From: Juan Baeza
Sent: 03 October 2011 15:43
To: Planning.Responses
Subject: FW: Greenoaks - Planning Application

Can this please be scanned as landscapes response to EG/33/11.

The development requires that established trees, including the conifer screen will be removed to allow for the development. So any opportunity to retain sizeable trees is desirable. However no amount of planting can mitigate what was there originally because the land will become occupied by new buildings and any proposed planting of ultimately similar sized trees will therefore be restricted, or subjected to harsh pruning.

PROPOSED SITE PLAN (1:200)

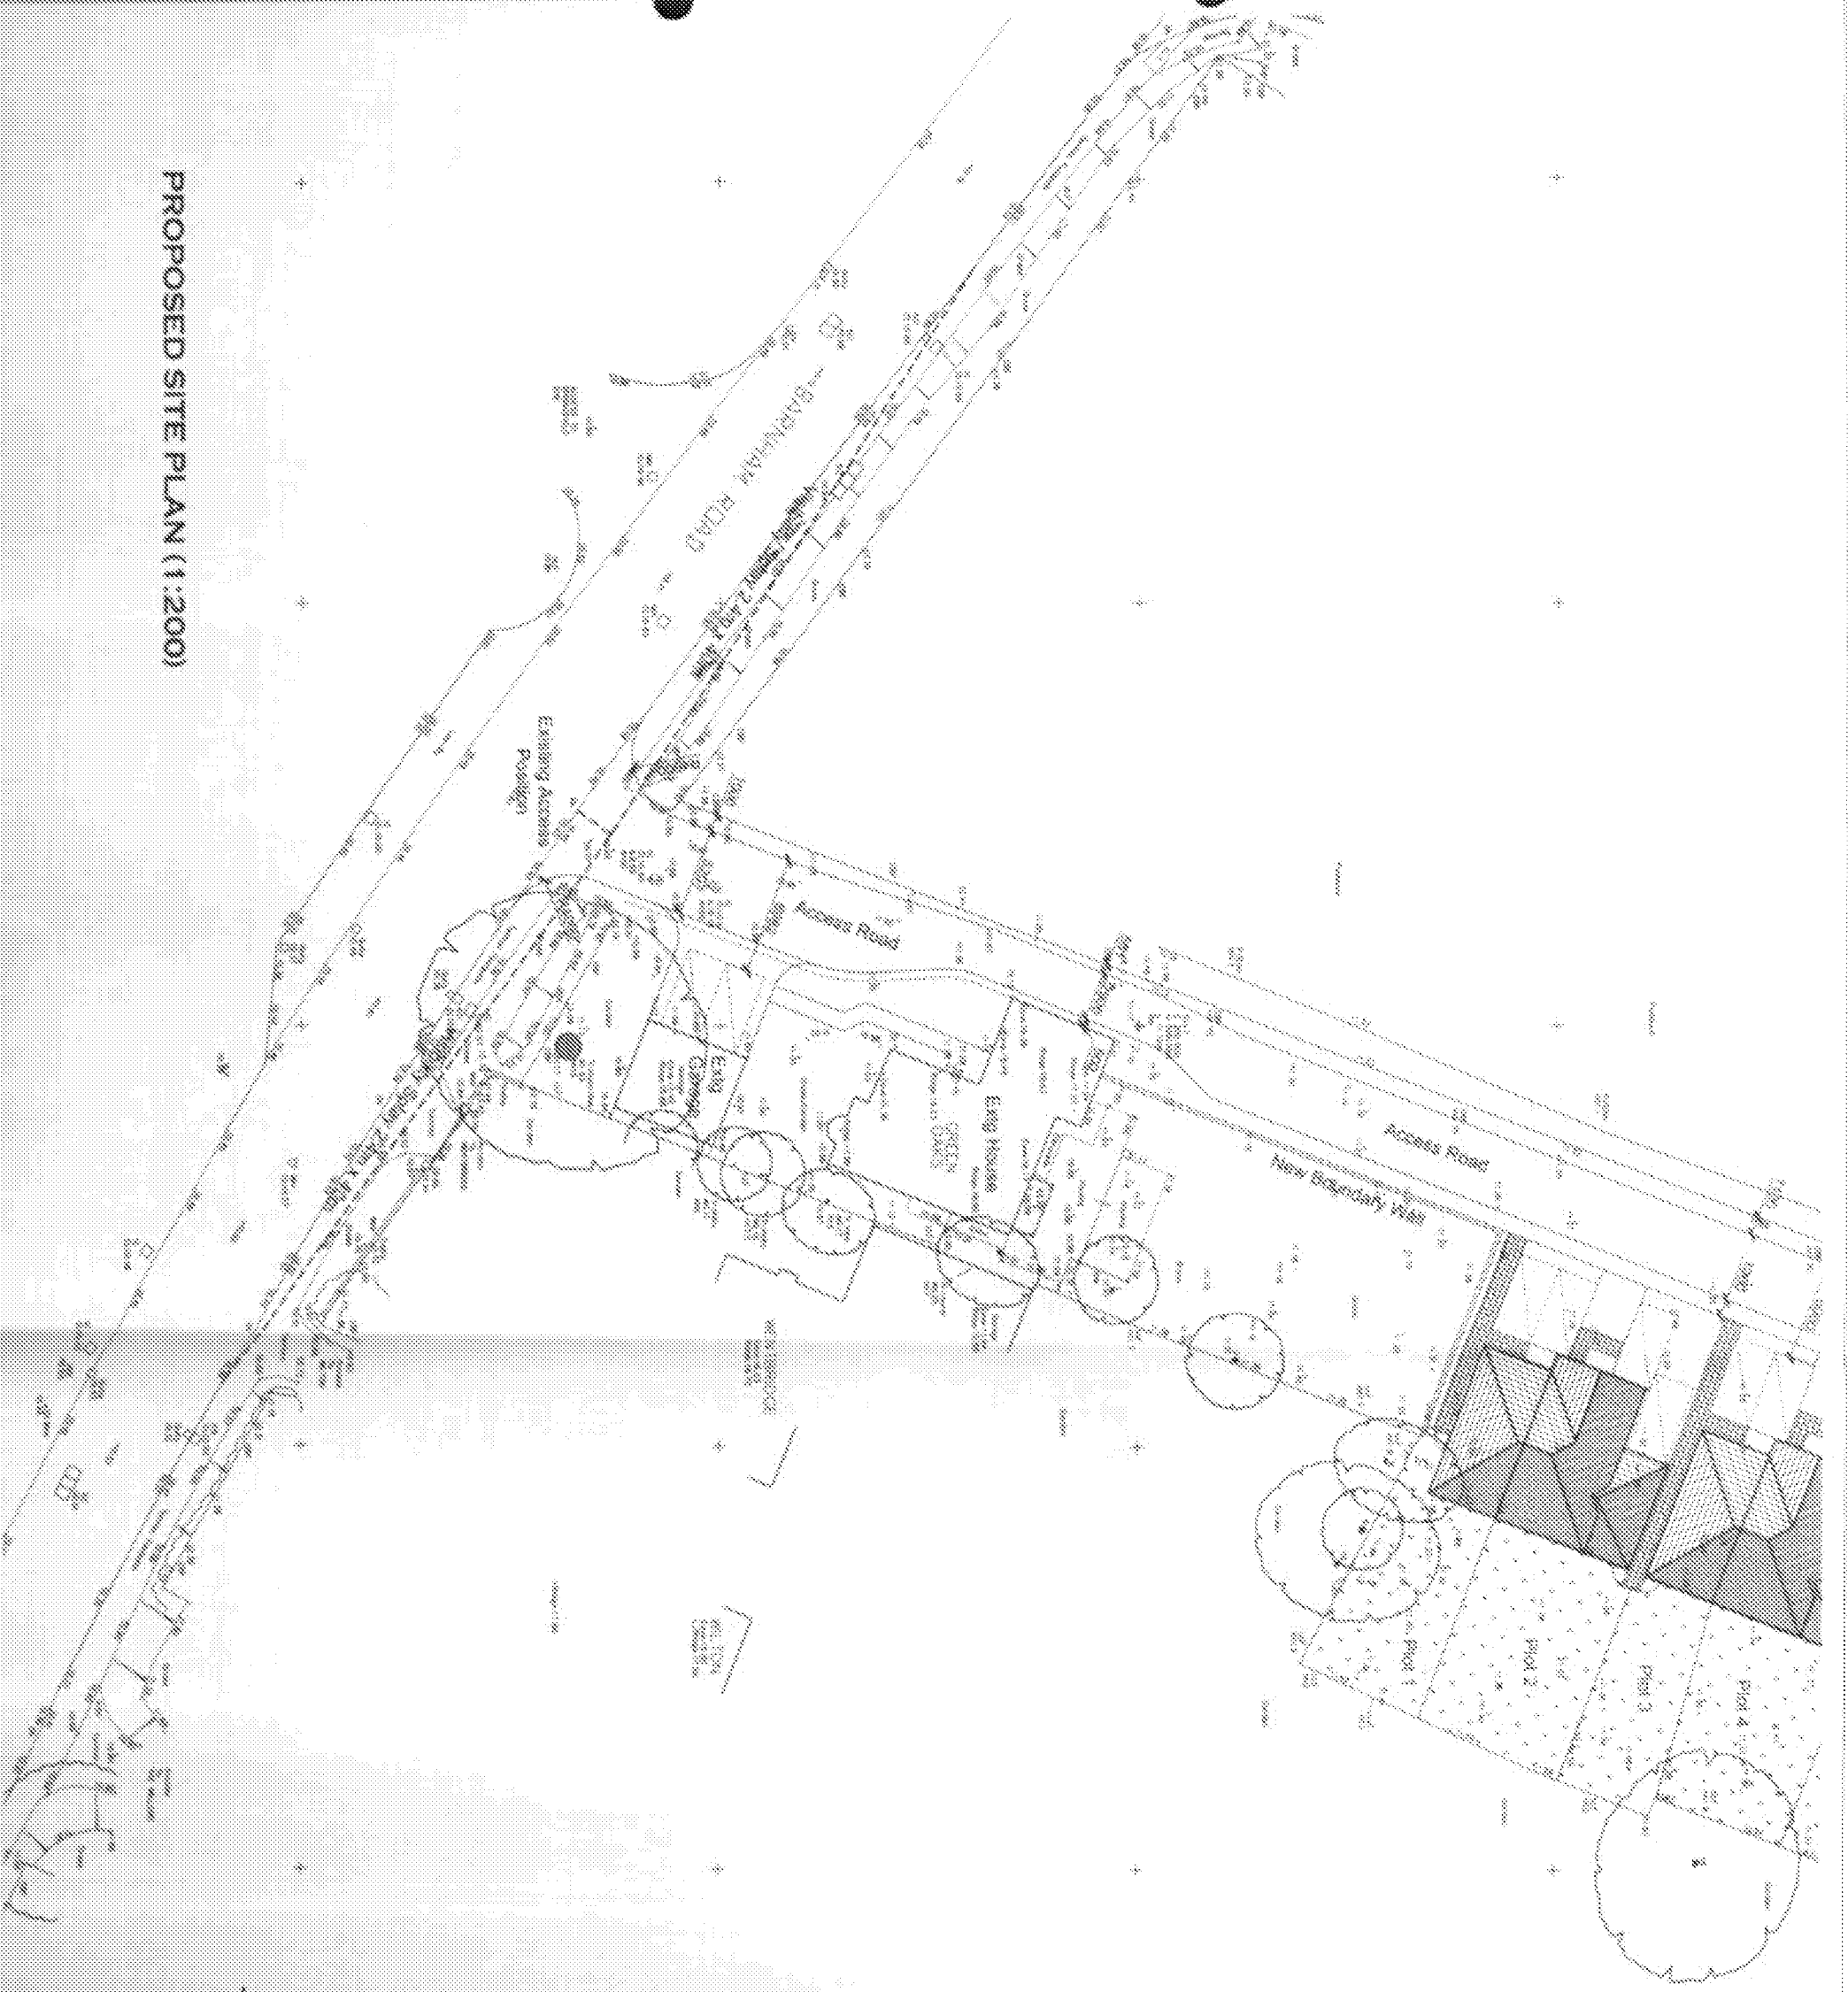
The trees referred to here T3, G4 and T14 are, and I would tend to agree with the tree consultant, limited in their visibility from the Barnham Road. However, within the context of the development, their visibility will become more apparent as the access road and new build near to them commences, raising their importance as a good visual feature of amenity within the overall landscape. It is desirable therefore to retain these mature trees by providing protection via protective fencing in accordance with the tree consultants recommendations for other similarly affected trees to be retained.

I note that T14 has been described as having some root severance on the west side. If this is found to affect tree stability during adverse weather in the short term then its removal and replacement would be required. In the absence of having a good reason to remove trees T3, G4 and T14 I would recommend that they are protected as part of the development proposal.
